# CITY OF ALBUQUERQUE

**Re: Garfield Apartments Grading and Drainage Plan, 501 Girard SE  
Engineer's Stamp dated 01-12-12 (K-16/D079)**

Grading & Drainage
Plan

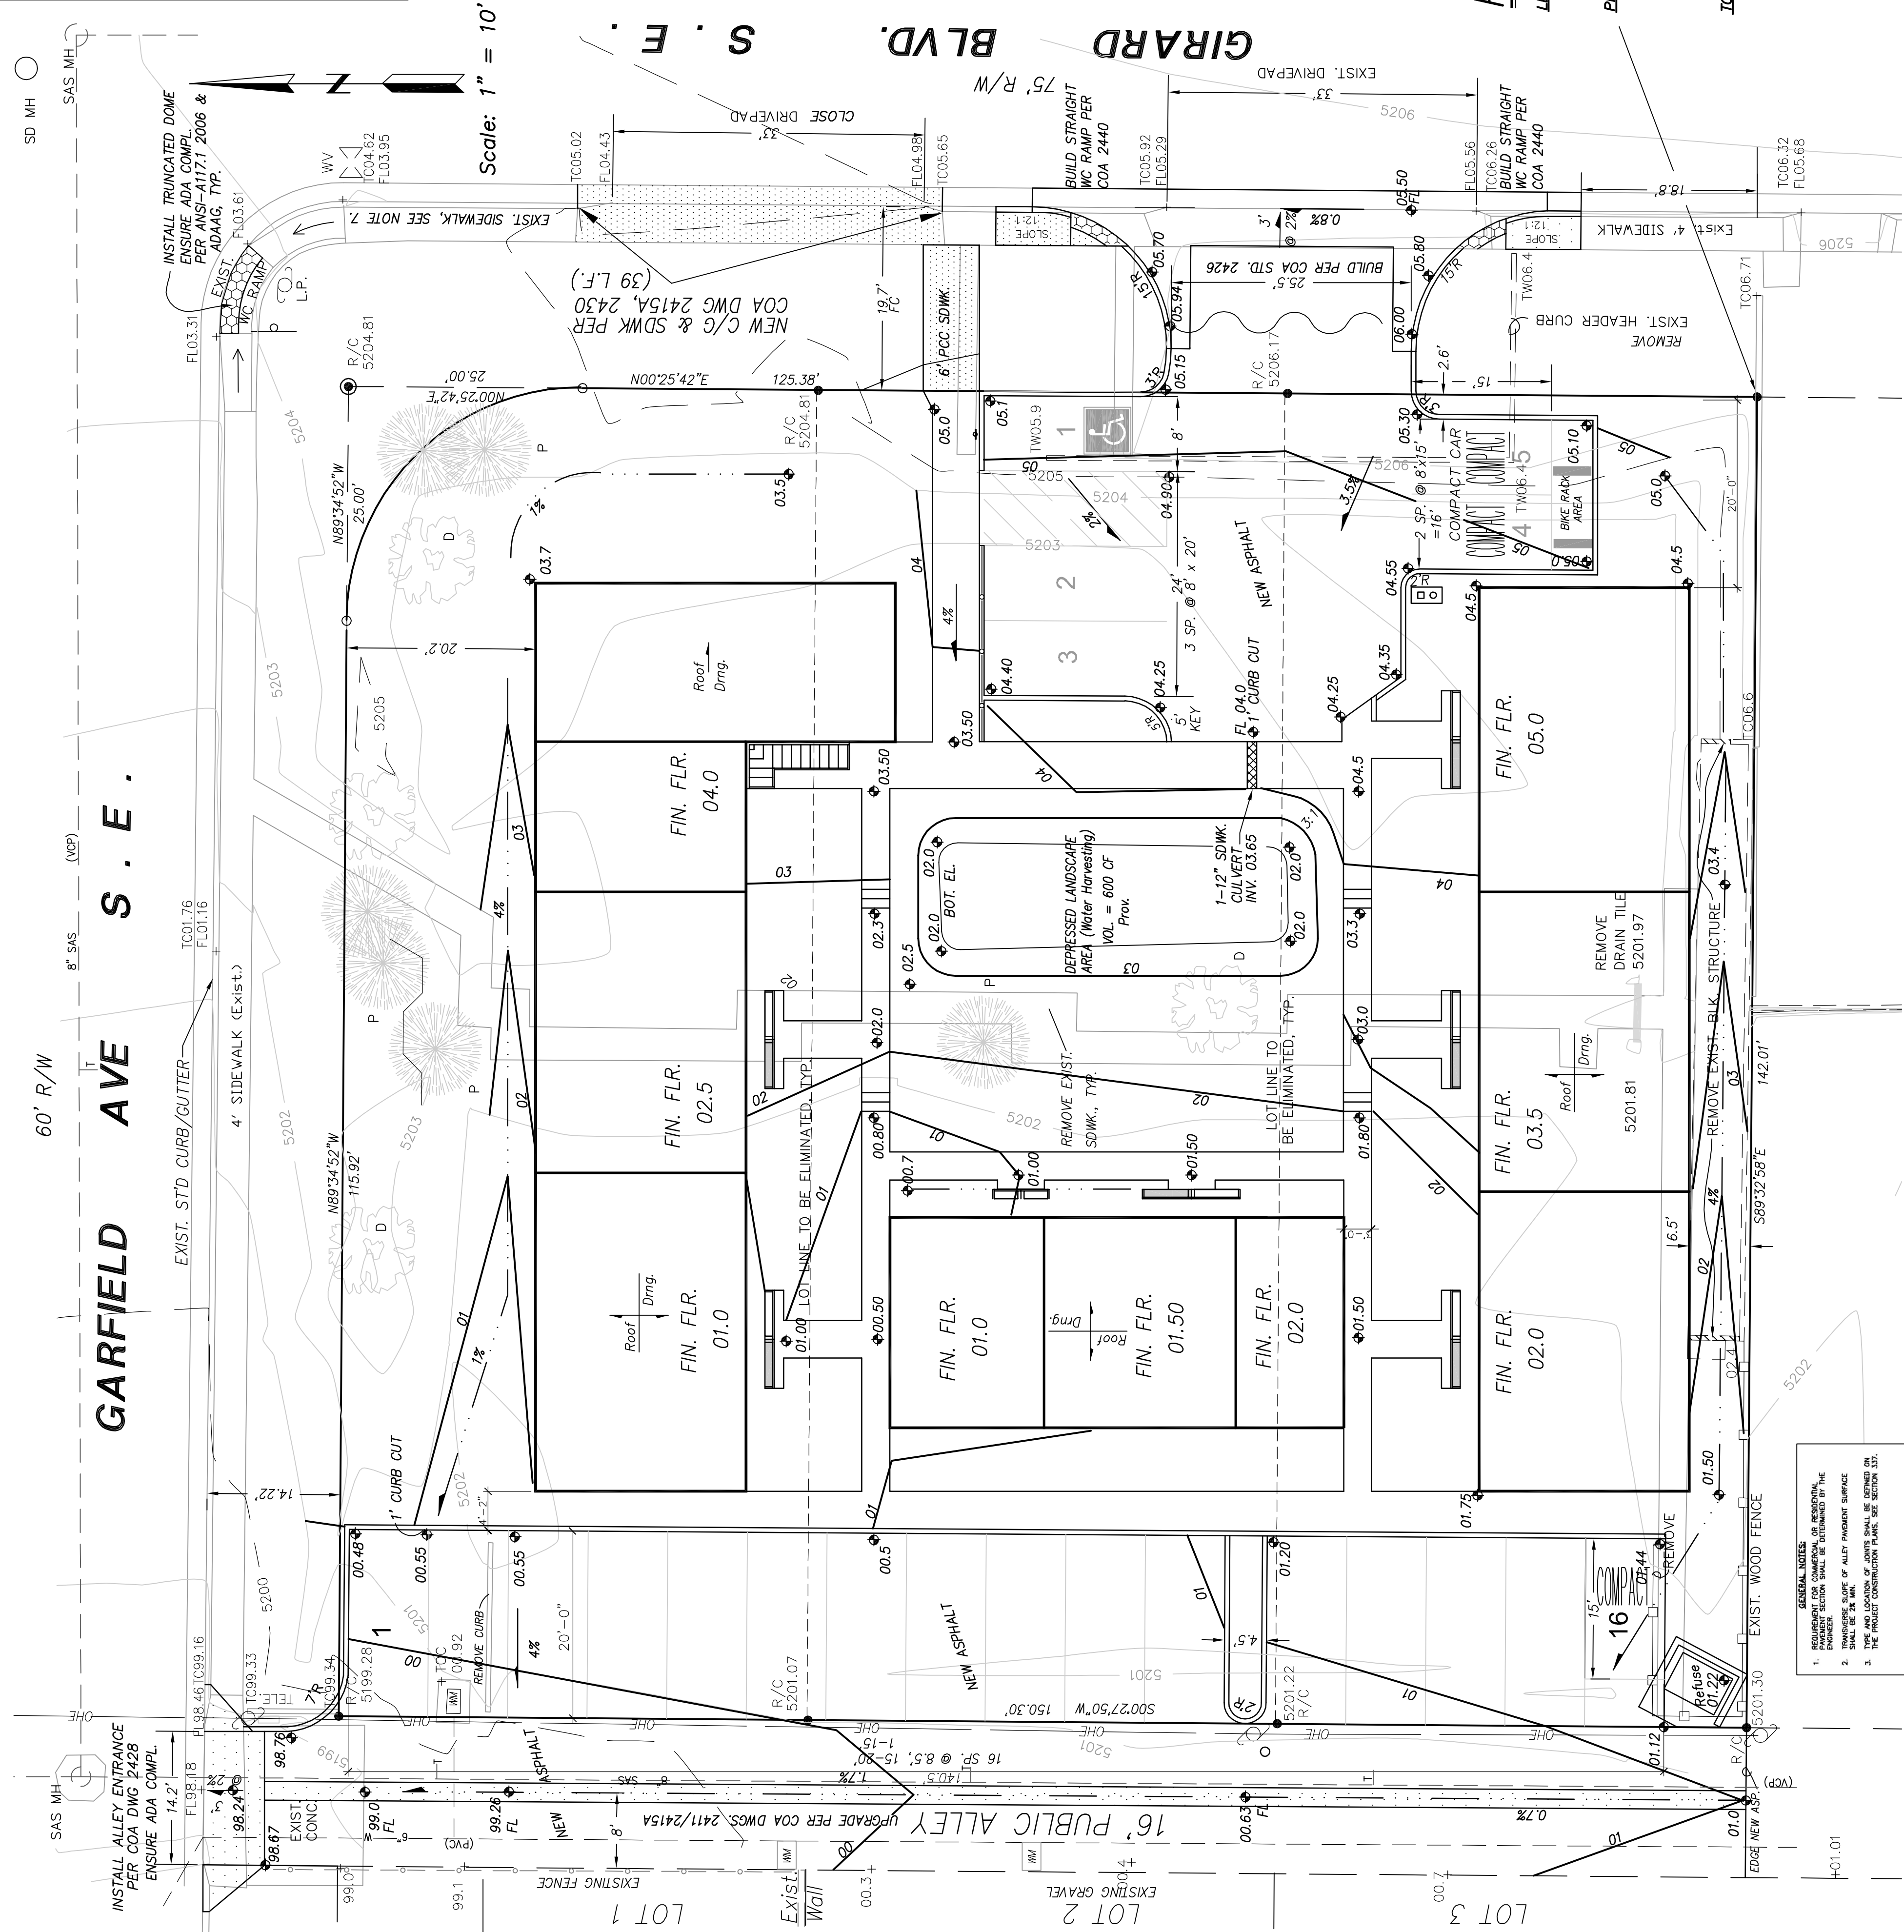
- Show additional existing spot elevations along the western portion of the public alley and south of the alley improvements to verify proper drainage.
- Show all accesses to other properties in the alley.
- Please provide more spot elevations just west of the water harvesting pond in the apartment complex to show how flows are directed around the building.
- Provide at least an 8" water block at the drive entrance on Girard Blvd.
- The landscaped areas on the northern portion of the lot should be depressed to capture the water that falls there.
